# KITITITAS COUNTY

### MEMORANDUM

TO: Community Development Services  
FROM: Taylor Gustafson, Environmental/Transportation Planner TG  
DATE: July 30, 2018  
SUBJECT: Public Works' Comments Short Plat LPF 18-00003 (Swauk Valley Ranch)  
(Despite CDS labeling this as a 'LPF', this is a 4 lot Short Plat, and will be reviewed as such. Preliminary Long Plat review for this application was under LP-17-00007)

Date: 3-28-18
Scale: 1"=200'
Drawn By: JG
Surveyed By: JG/TB
Checked By: JG
Sheet 1 Of 3
Job Number: 2016-SWK

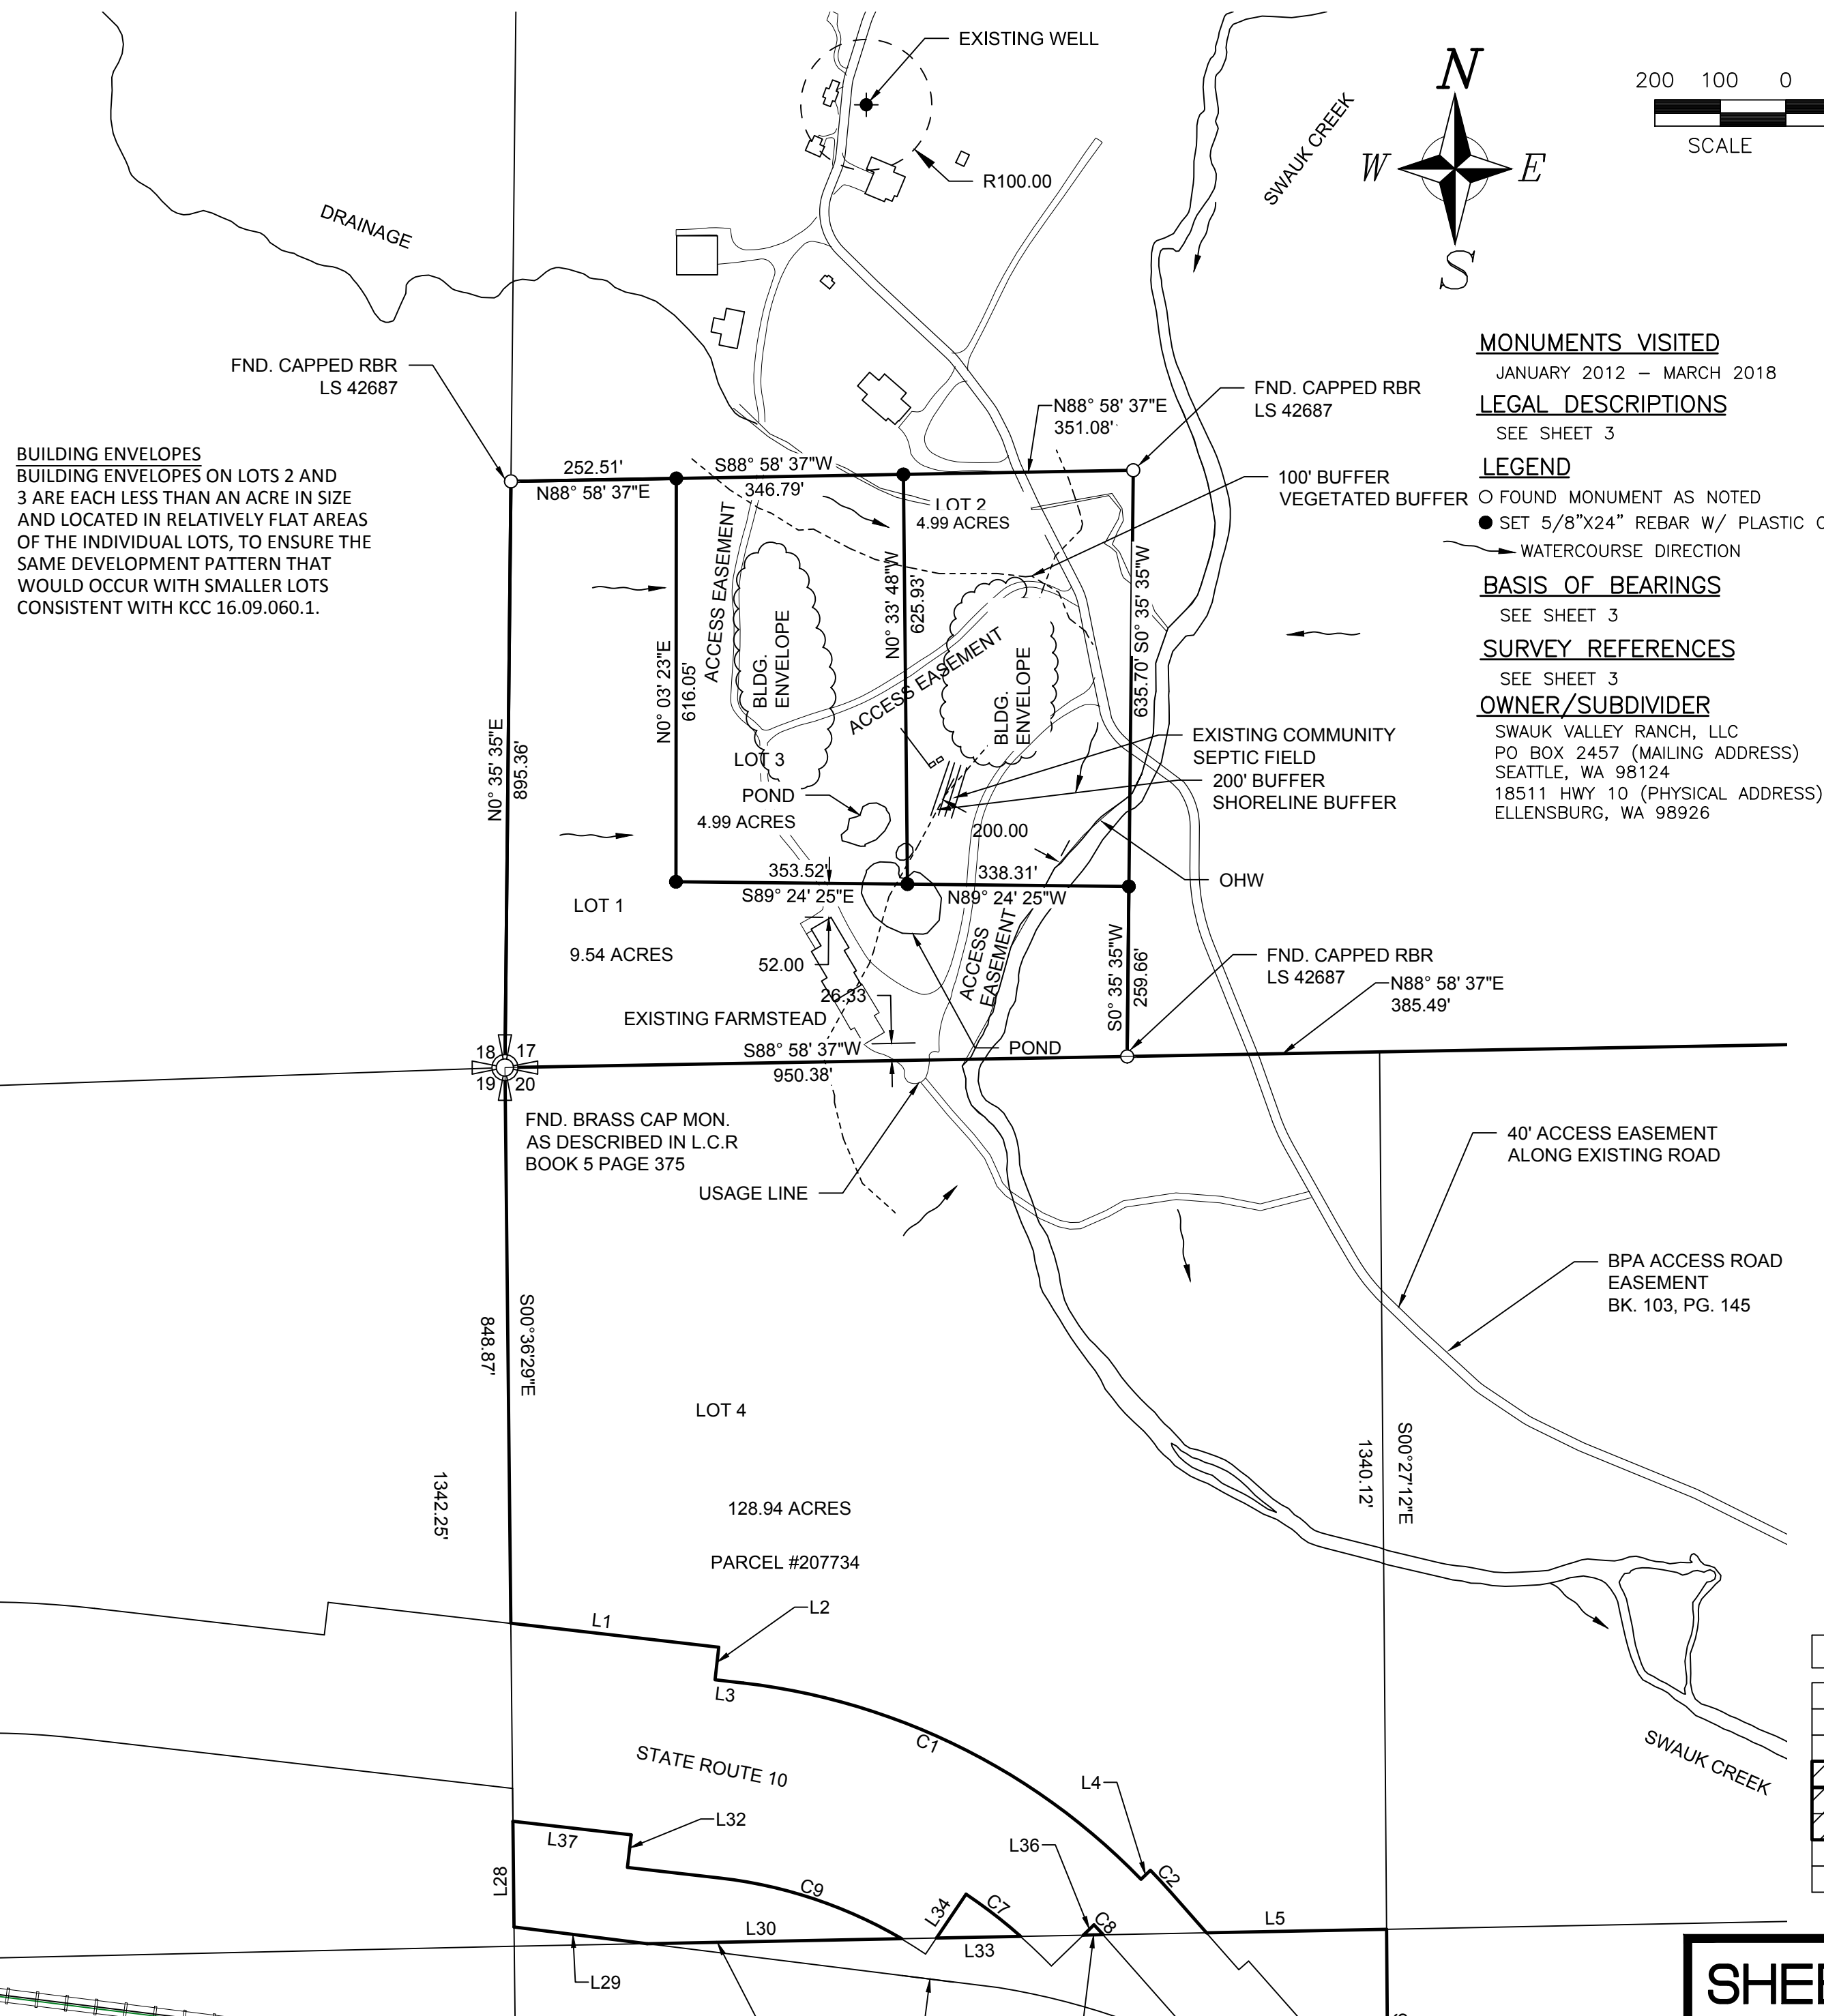
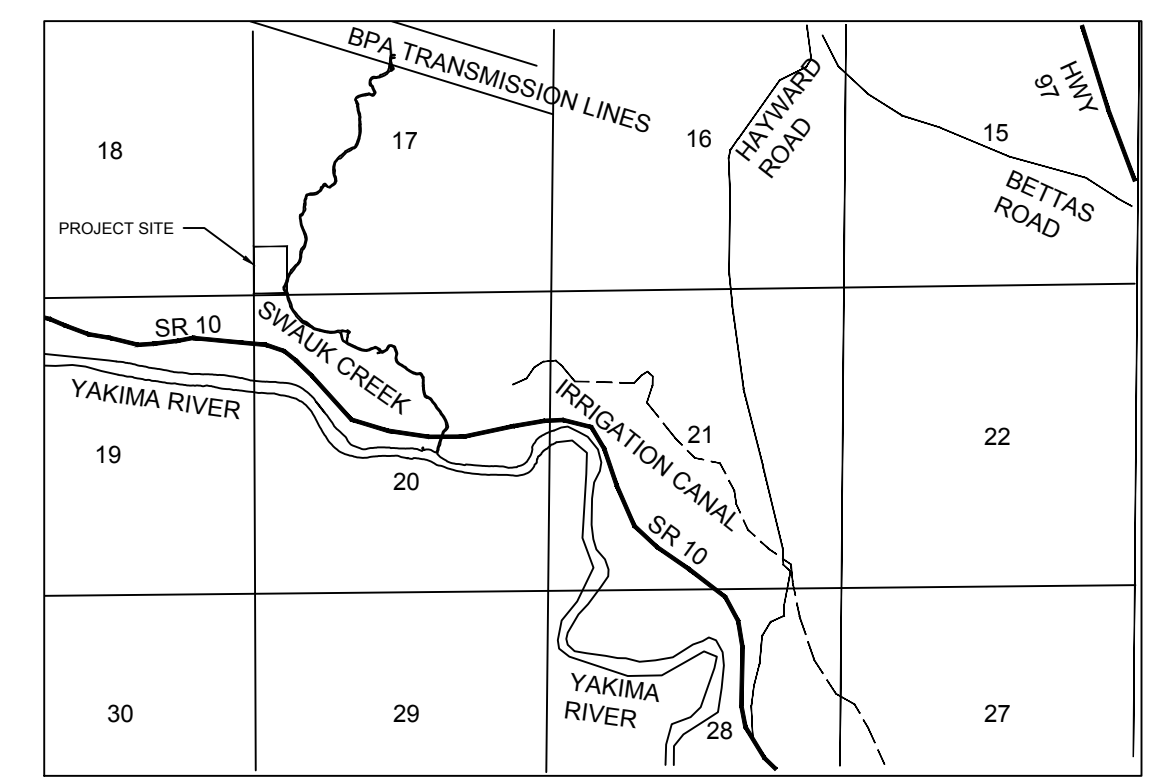
6. The access easement should be addressed as existing or herein dedicated. If existing, the recording number should be included, and if dedicated, the position should be mathematically retracable.

7. The roads identified as Pvt. Roads on lots 1-3 should be revised to include easements to provide legal access to the new parcels.
8. The BPA access road should be identified as where it begins and the 40' Access easement ends (or overlaps identified). The 40' Access road should include the recording number of the easement document.

9. There are unusual breaks in linework along roadways and creeks. This is particularly problematic near the East line of Lot 4, where it is confusing with the intersection between the creek and the access.

10. The area north of parcels 1 and 3 identified as R100.00 should be identified. Additionally, if this well is to serve lots 1-3, easements should be shown connecting said parcels to the well.

11. The building on Lot 1 should show distances to the North and South Property lines to ensure it meets setback requirements.
12. It appears that a portion of Lot 4 is being used by Lot 1. This usage line should be identified.
13. There are portions of Lot 4 that fall south of SR10. As these portions are a part of the land to be divided, they should be delineated. The railroad right of way may also contain a small sliver of the largest undelineated parcel.
14. One of the corners of Lot 3 shows it as being set in the pond.

Sheet 2 Of 3

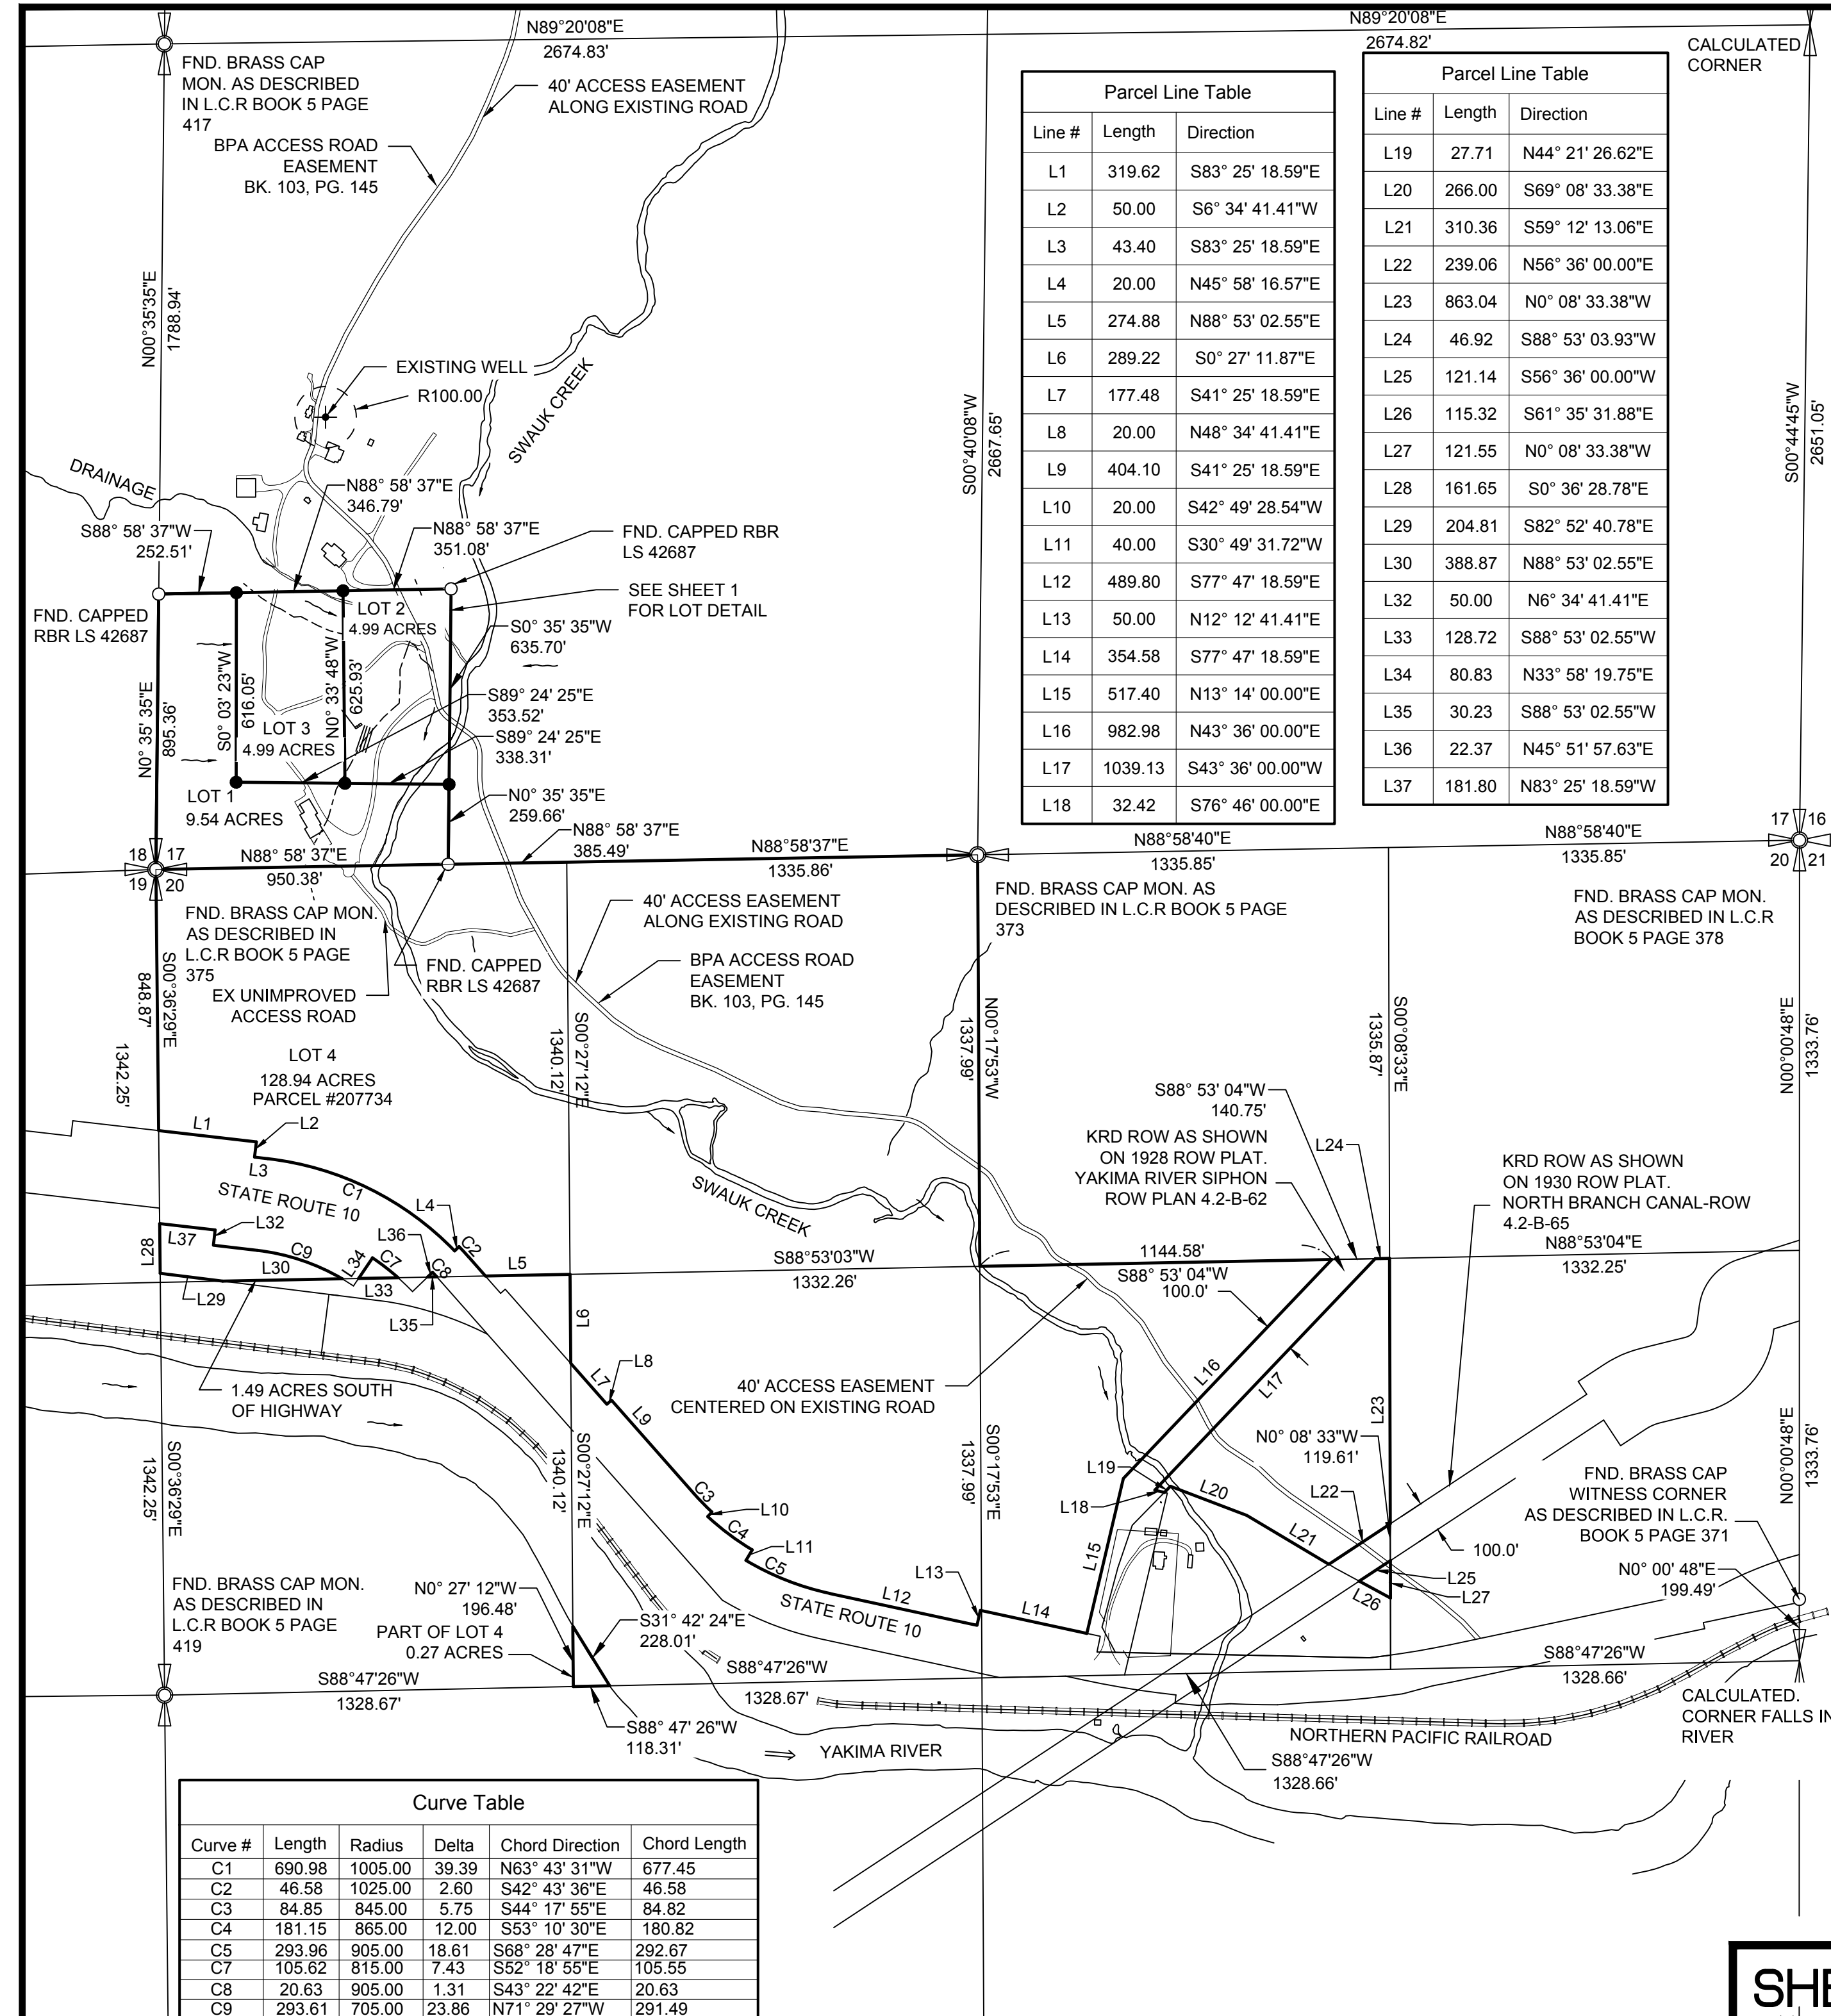
15. The Leader arrow to the Witness corner at E1/4 of Sec 20, does not point to the witness corner.
18. There appear to be usage across Parcel 4 by the adjacent parcel to the East, near line L16. Usage lines should be identified. This same parcel appears to be outlined and overlaps onto Lot 4 or the KRD r/w. This should be identified.
19. The closure reports do not match the radii as shown on the curve table.
